Please ask for: Ms Iqraa Malik
Email: iqraa.malik@terraquest.co.uk
Telephone: 01212341390
Our Ref: FP/77/21/HH
Your Ref:
Date: 9th April 2021

Application for Planning Permission for Works or Extension to a Dwelling

Development: Ground floor extension to provide wet room
Location: 59 Minton Road Felpham West Sussex PO22 7JX

FLOOR PLAN - 1:50

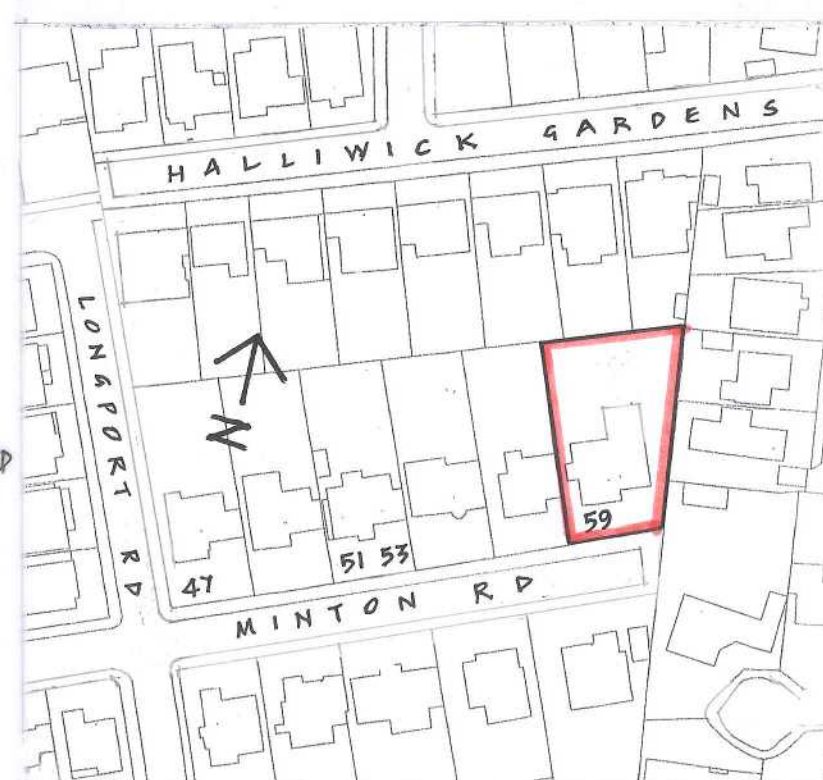
Plans: Please provide a full proposed floor plan clearly showing where the extension is proposed

BLOCK PLAN

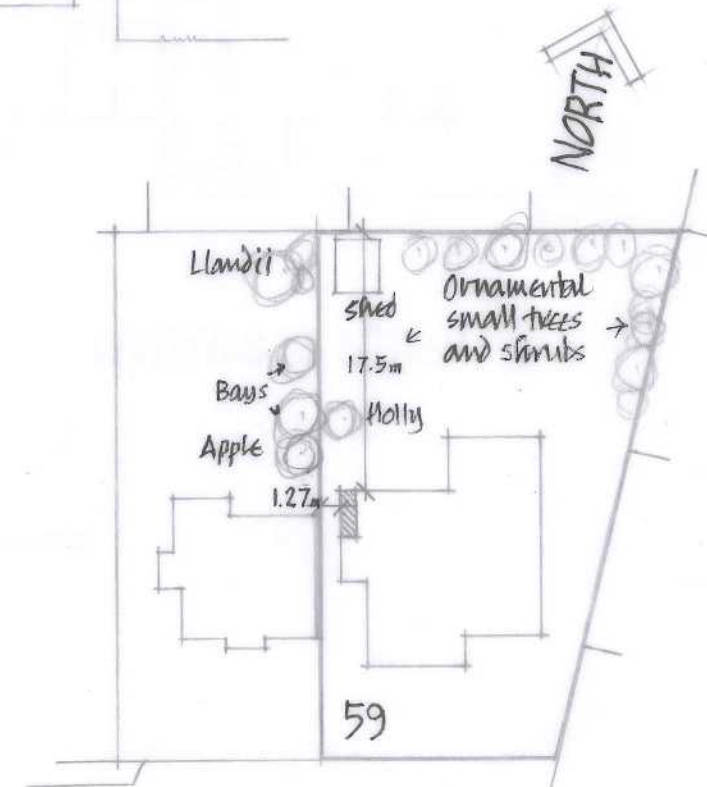
Block Plan

Please submit 1 electronic or 3 paper copies of a block plan at a scale of 1:500 with dimensions to the site boundaries. Further details of what must be included on the plan can be found in the Validation Requirements List.

GROUND FLOOR PLAN

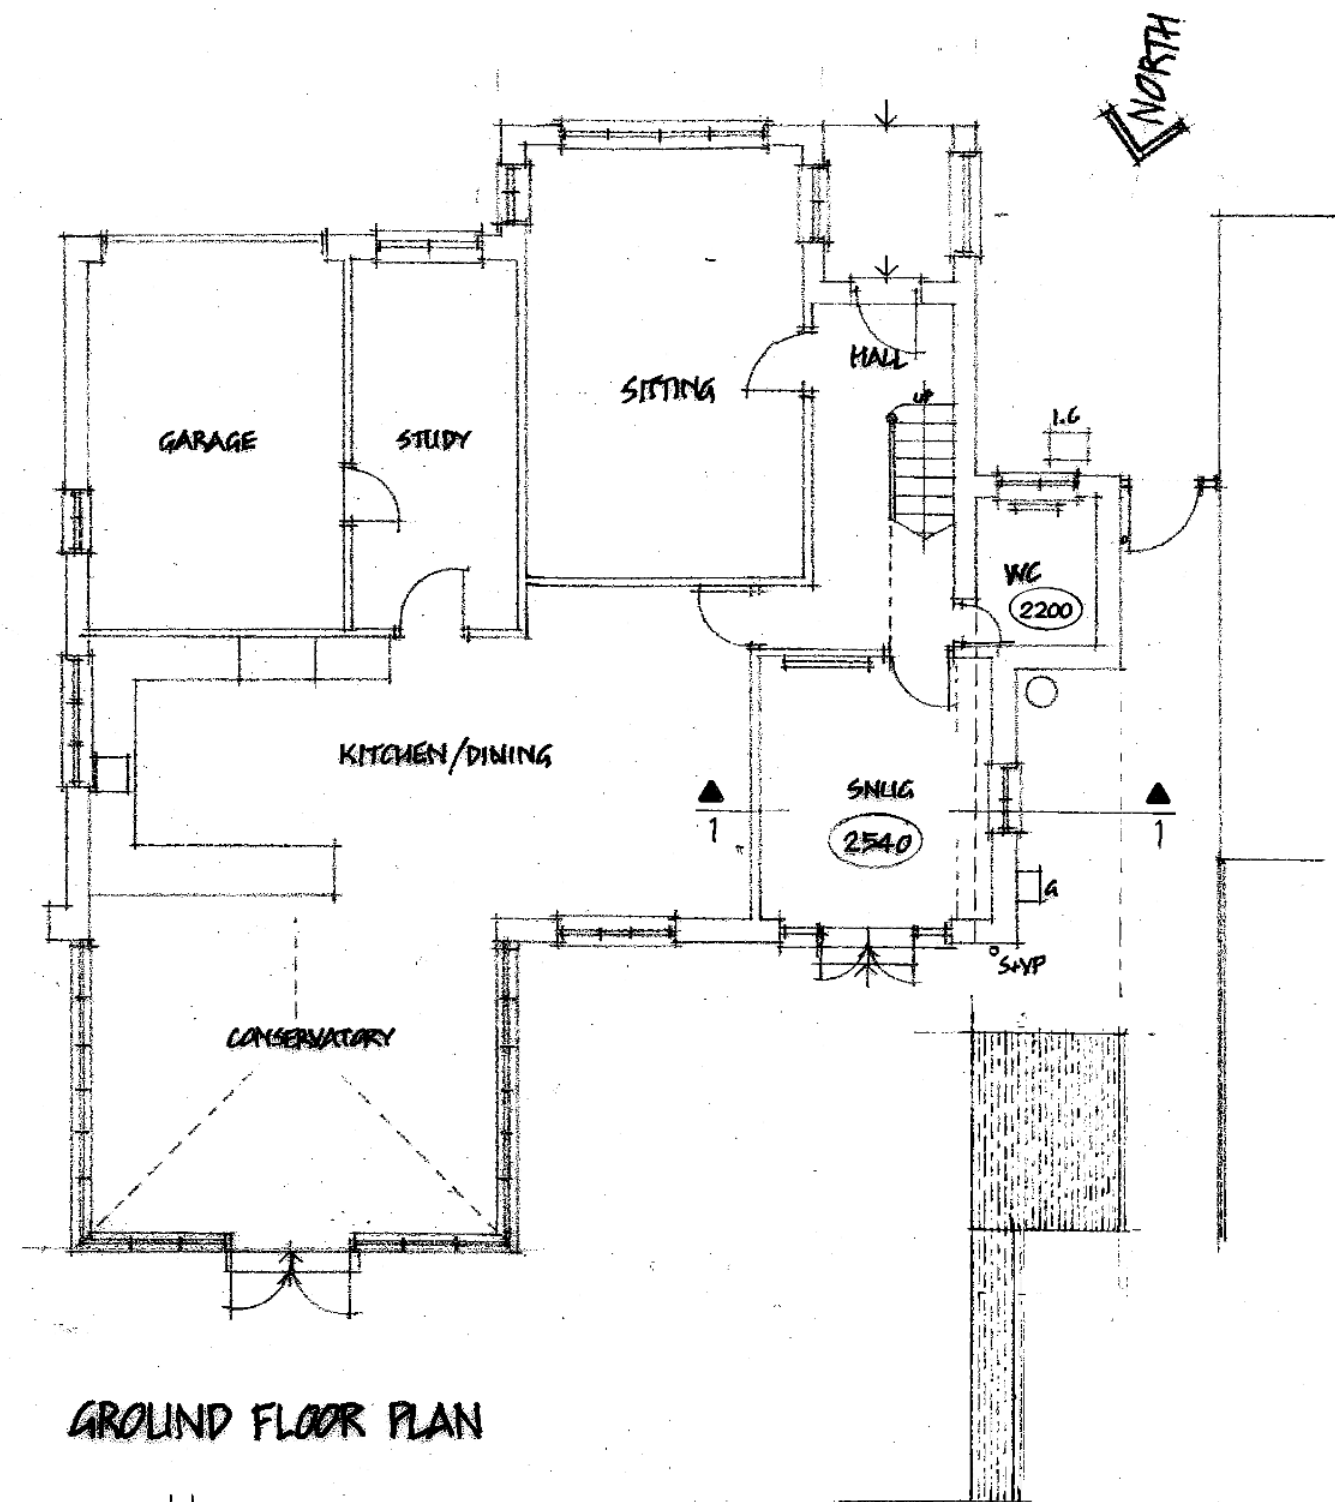
Existing Floor: The existing floor plan is cut off please provide a clear floor plan
